Planning Application No: 3/2024/0239

I am sending this letter, detailing our objections to the proposed two-storey three-bedroom dwelling in garden with new access and associated alterations to original dwelling, location, 24 Nickey Lane, Mellor, BB2 7HF.

Drawing Title
PROPOSED ELEVATIONS

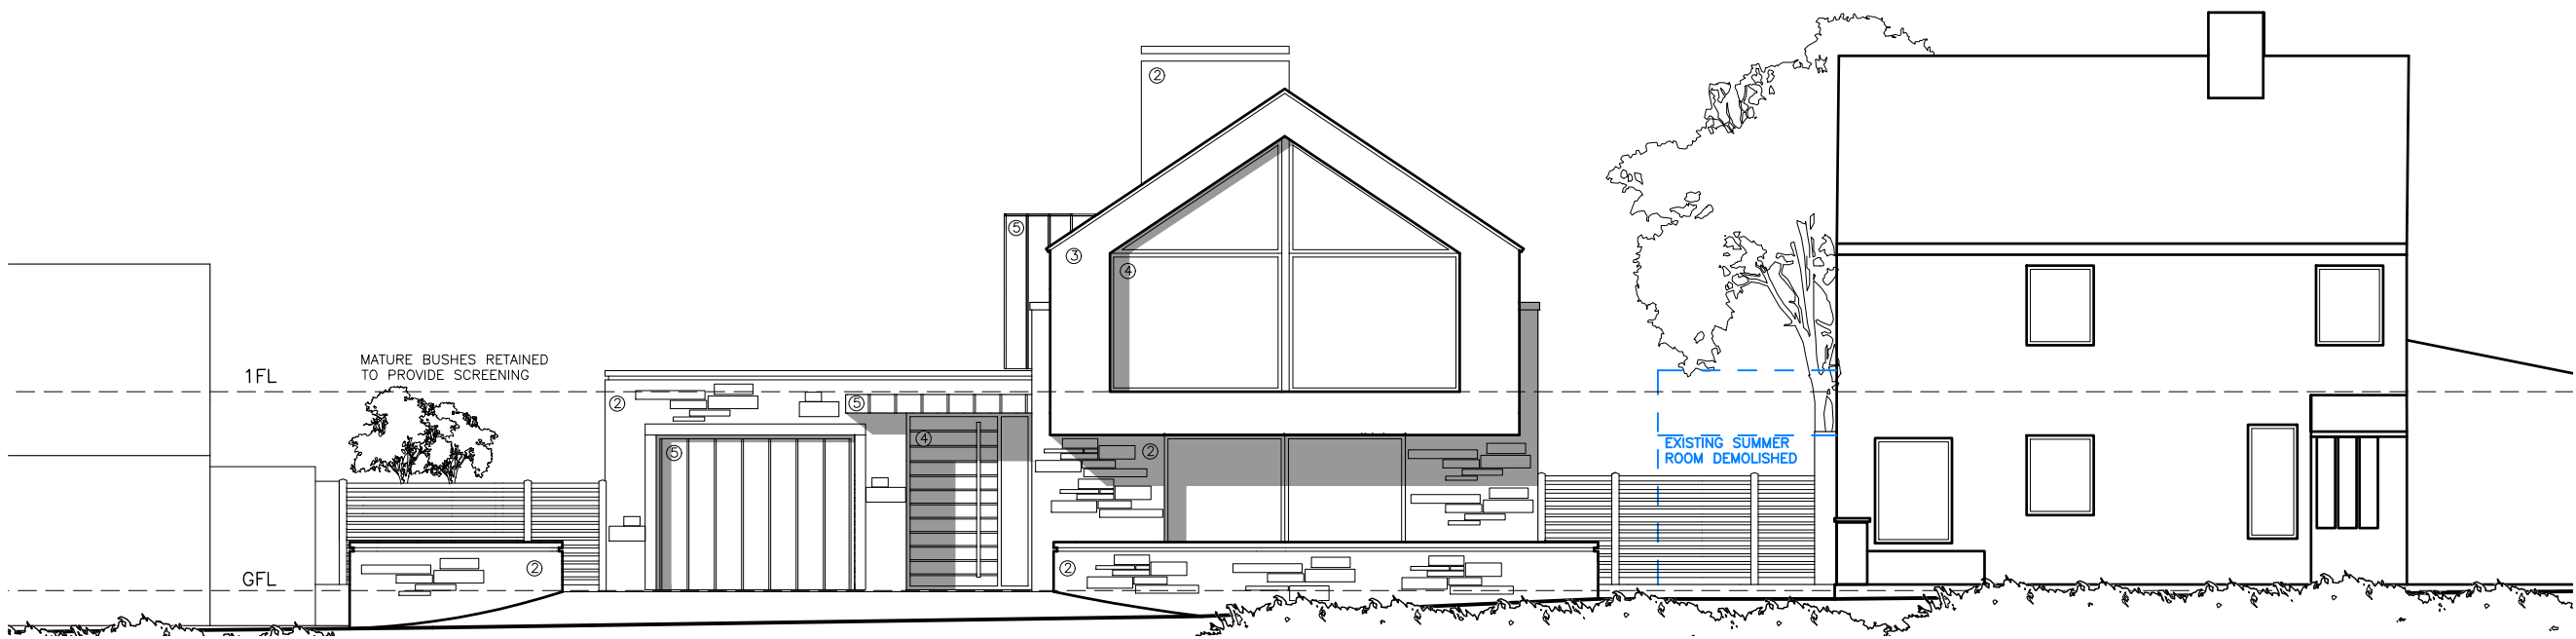
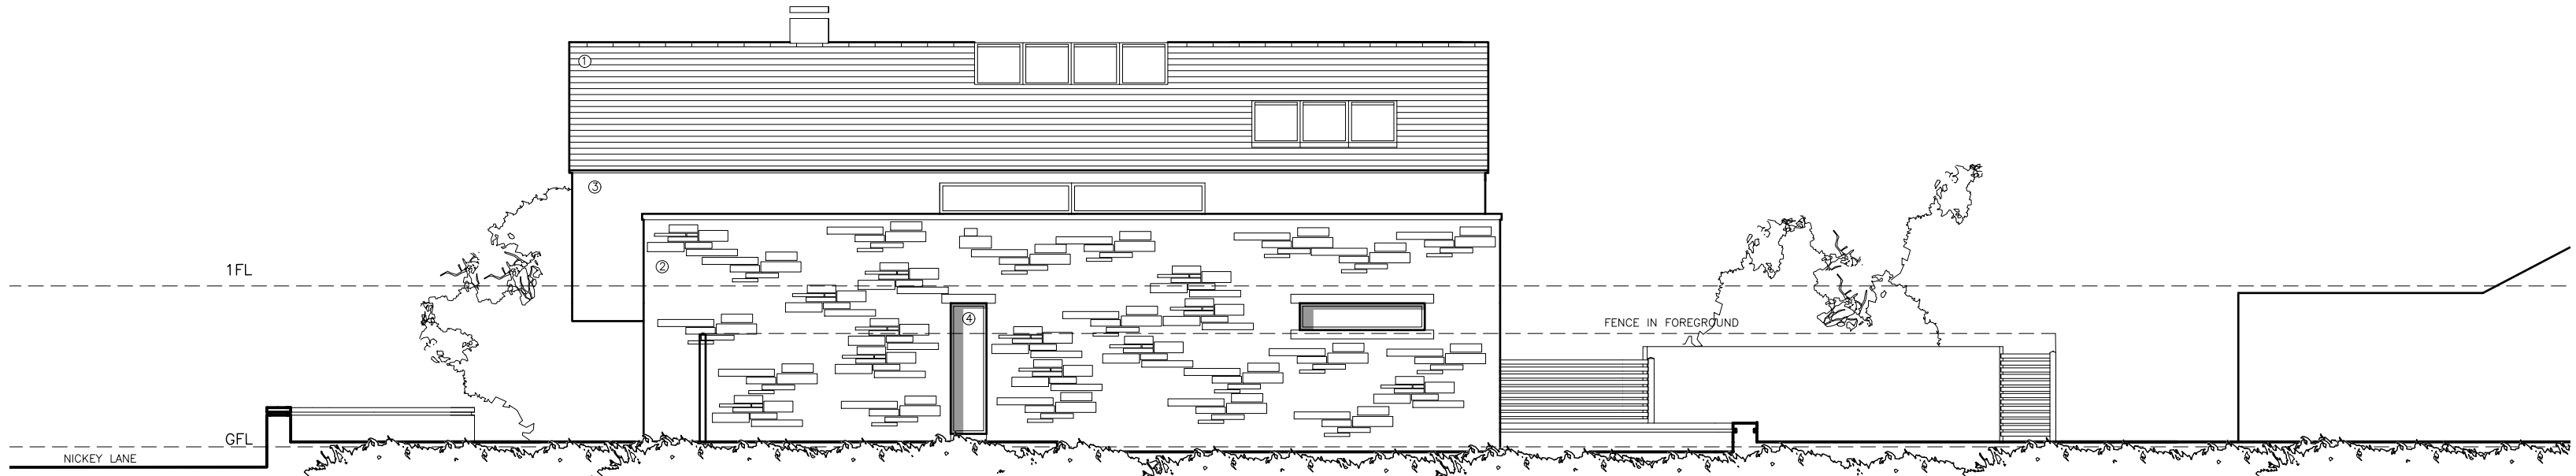
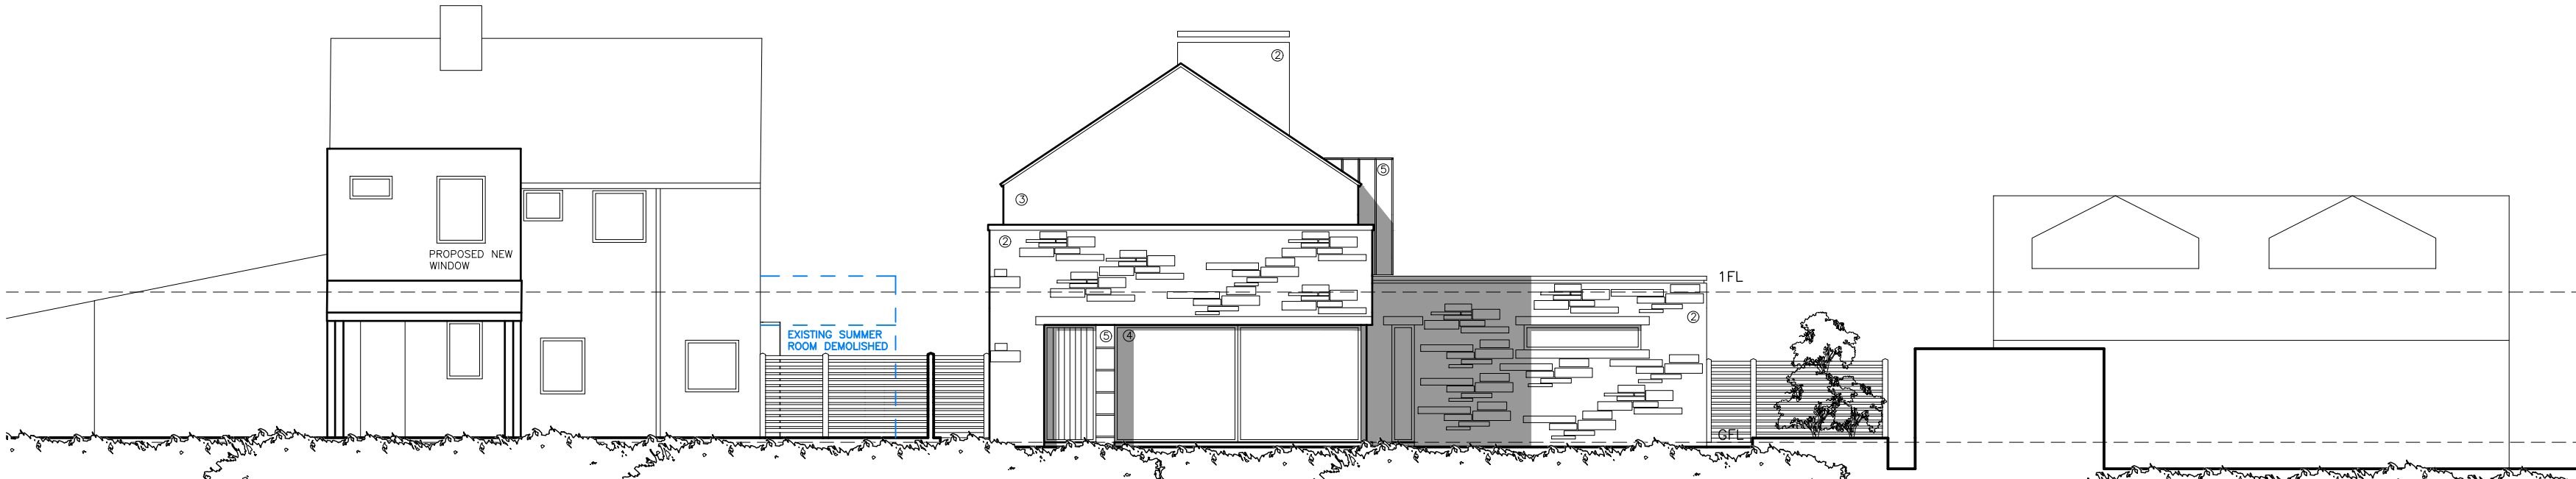
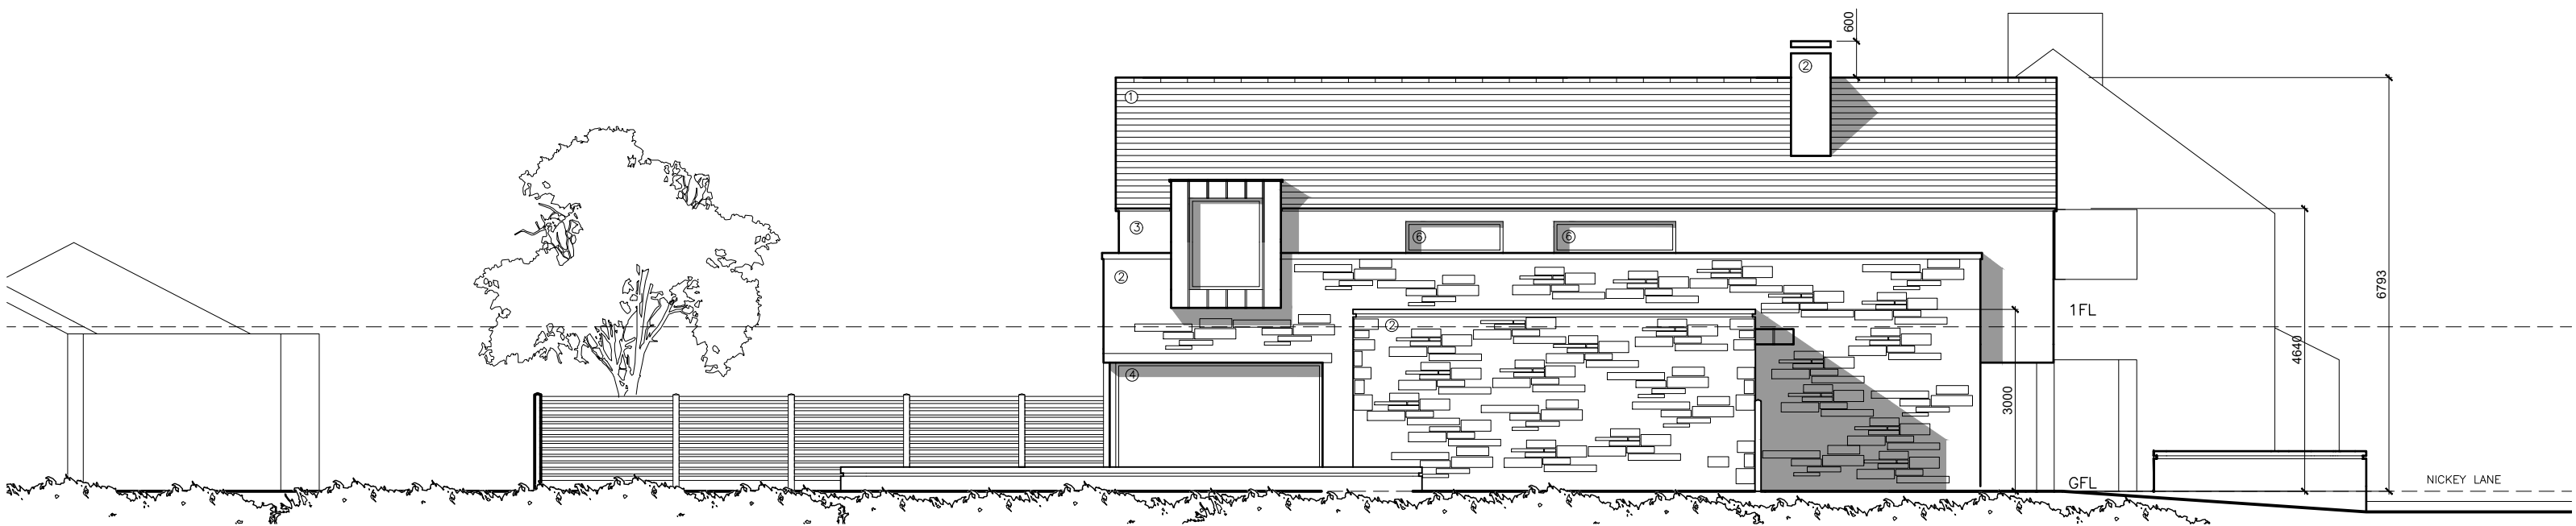
I have also enclosed a copy of the printed plans, showing, proposed front (East) elevation and proposed rear (West) elevation, showing my objections, drawn out in red ink with a reference to each drawn line:

We note from the proposed plans of the two-storey building the master bedroom window will [REDACTED]

The master bedroom window of the proposed property will [REDACTED]
again causing a lack of privacy (reference B).

The master bedroom window of the proposed property [REDACTED]
[REDACTED] (reference C and D).

We note on the plans that mature bushes are to be retained for screening, during the summer months, yes, they may offer some privacy though during the winter months when the bushes and trees shed their leaves, the same screening cannot be offered (reference E), we also feel that the proposed new building will encroach [REDACTED] now we are afforded a lovely view [REDACTED] being a good distance away from our home, if the proposed new build goes ahead [REDACTED]
[REDACTED]
